Norwich to Tilbury

**Document: 8.3.10 Draft Statement of Common Ground - Equinor
- Tracked Changes Version**

May 2026

Equinor

Overlap Area plan

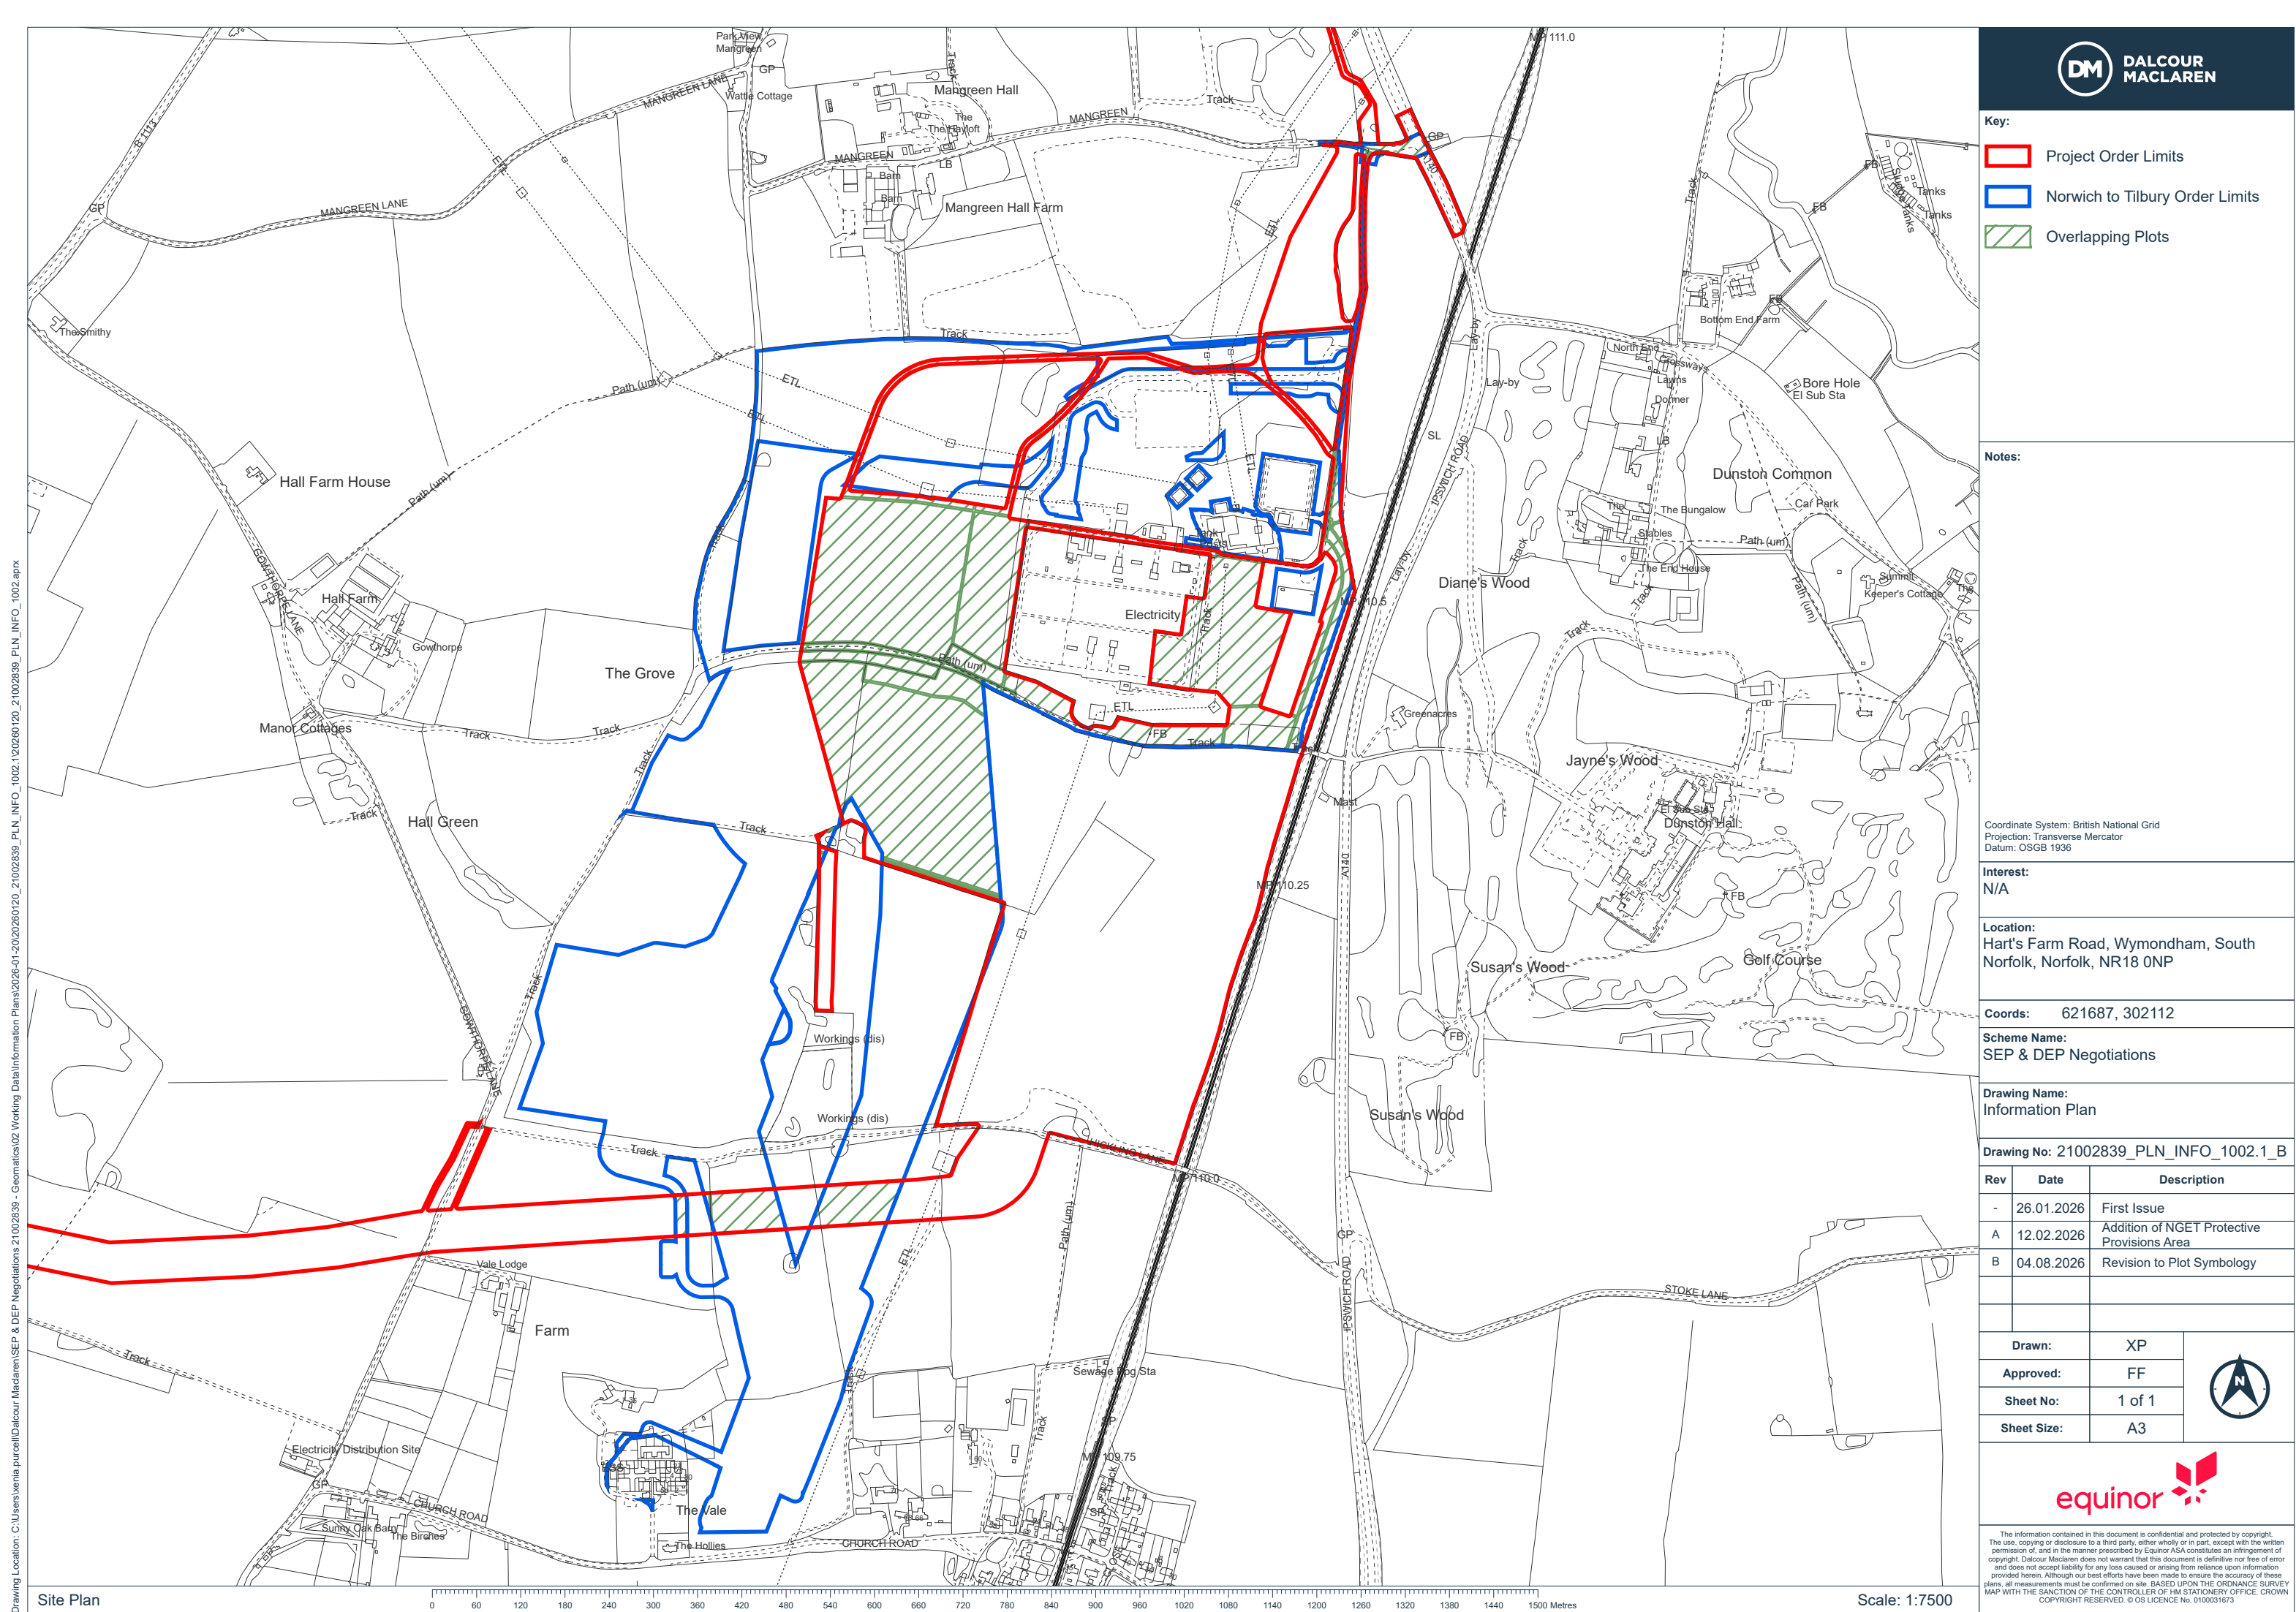
ID	Issue	Stakeholder position (including date)	National Grid response (including date)	Relevant documentation	Status
6.1	Limits of deviation flexibility	27/11/25 - The Norwich to Tilbury Order limits to the south of the Norwich Main substation provide for two routes for the new pylons, within the limits of deviation. The eastern option would lead to a high degree of overlap with the SSDE DCO Order limits and pose significant constraints on the construction of the 400kV cable, the onshore substation and surrounding works which are critical to the delivery of SSDE. Seeking such a high degree of flexibility for the Norwich to Tilbury Order limits at this location therefore poses serious concerns for SSDE, risking SSDE ProjCo Limited's ability to deliver SSDE.	15 24/0204/26 - National Grid The Applicant is undertaking further detailed design engagement with parties within the scenario options with a view to providing a definitive project corridor and removing uncertainty. National Grid ahead of DCO examination close. Any such utilisation of the eastern corridor would be done only in consultation with SSDE ProjCo Limited. The Applicant will continue engaging with SSDE ProjCo Limited and notes the		In discussion

ID	Issue	Stakeholder position (including date)	National Grid response (including date)	Relevant documentation	Status
			points raised and the preference for the eastern corridor not to be utilised.

Haul road and cable corridor interaction area

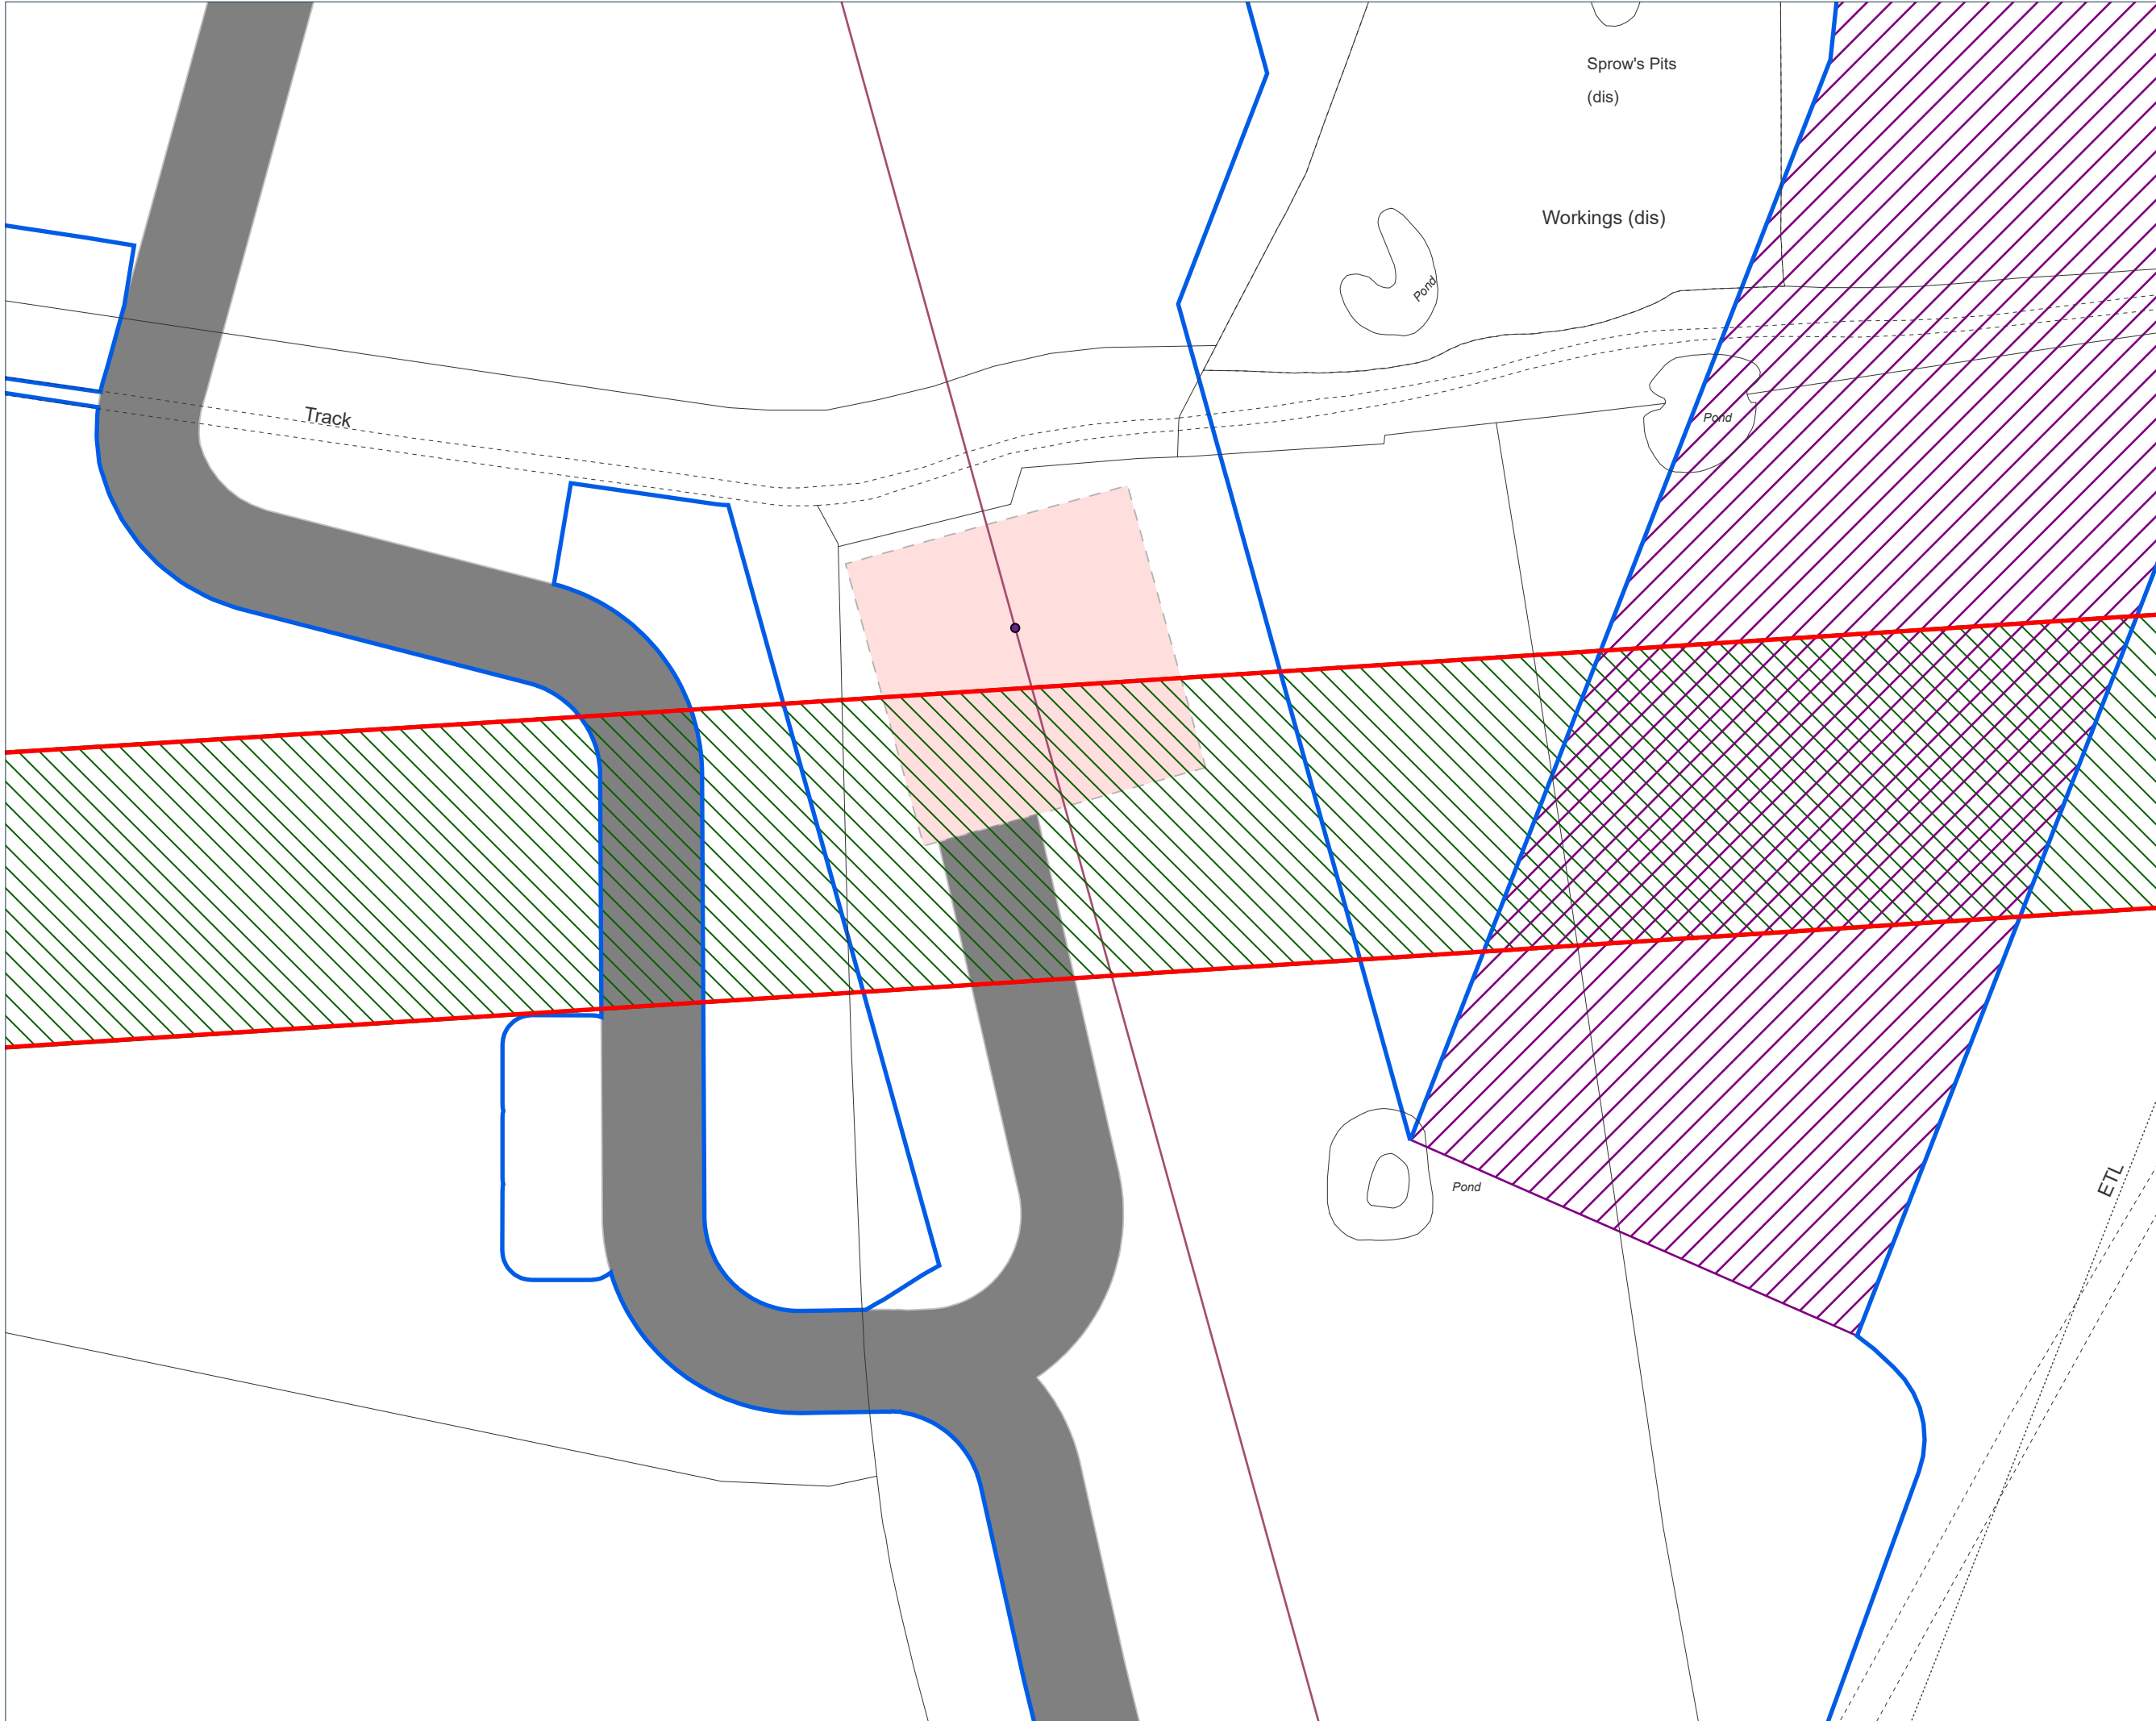
6.4	NGET Haul Roads	<p>27/11/25 - According to the Norwich to Tilbury Proposed Project Design [APP-133], NGET is proposing construction haul roads in locations which directly conflict with the SSDE DCO Order limits. The haul road crosses the SSDE DCO cable corridor twice and creates conflicts in other locations. This causes a potential risk to the construction of SSDE, as access through the SSDE cable corridor must be maintained and secured for the duration of the proposed construction phase for cable installation</p>	<p>15/24/0204/26 – National Grid and its delivery partners will engage The Applicant are engaging with SSDE ProjCo Limited to seek to ensure access is maintained for both the SSDE cable installation and commissioning works as well as the within Norwich to Tilbury delivery phase.</p>		In discussion
